CLAREMONT BUSINESS PARK 2 FIL. NO. 1 - LOT 1

EL PASO COUNTY, STATE OF COLORADO
GRADING & EROSION CONTROL PLAN

EPC STORMWATER REVIEW COMMENTS
IN ORANGE BOXES WITH BLACK TEXT

GRADING & EROSION CONTROL PLAN
CLAREMONT BUSINESS PARK 2 FIL. NO. 1 - LOT 1
JOB NO. 44-037
DATE PREPARED: SEPT 04, 2020
DATE REVISED:

SHEET 2 OF 4

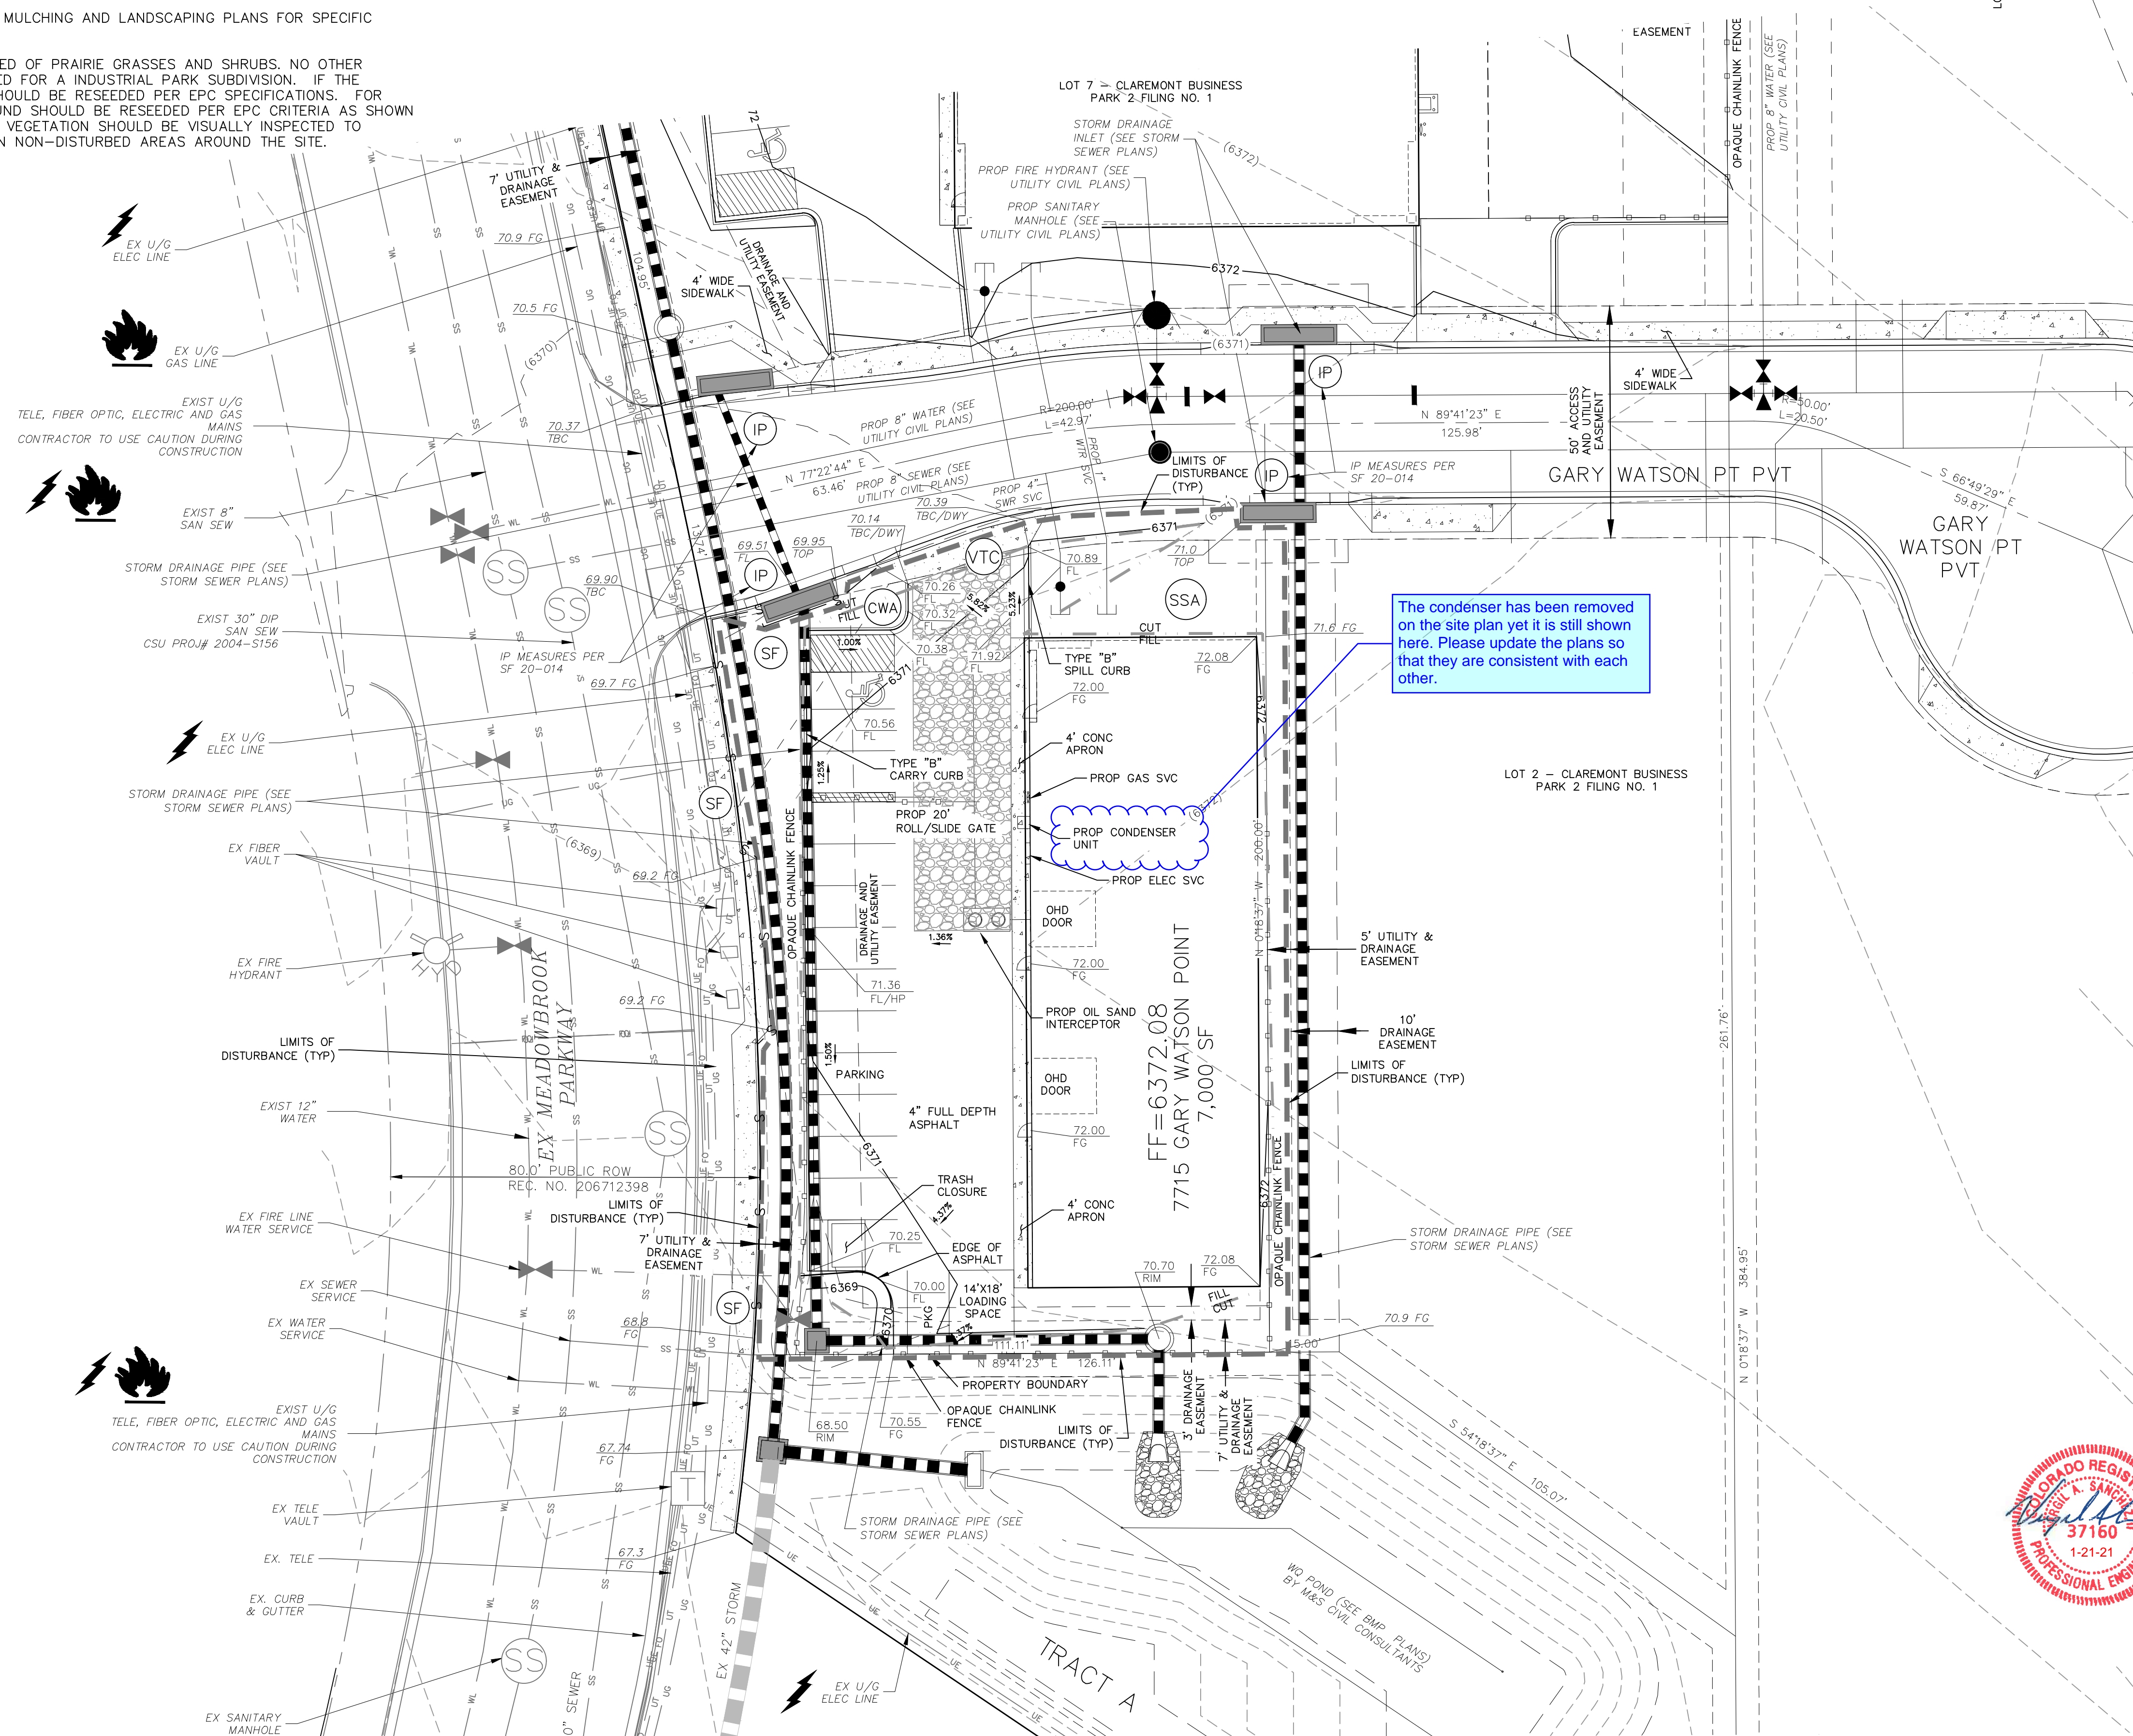
Item 1: include note about condition and type of existing vegetation

include details for CWA, Seeding/Mulching, SF, SSA, and VTC (w/ min 75ft length)

PCD Engineering reserves the right to make comments on the GEC until the FDR comments have been addressed, and a site specific plan is submitted within the FDR.

If same as Construction Boundaries, revise label to say: "Limits of Disturbance / Construction"

Add the following items to the Legend:
- Drainage flow arrows
- cut/fill line

Hatch areas to receive permanent seed/mulch and/or add a note stating the criteria for when/how/where seeding will be done (example: disturbed areas not being landscaped).
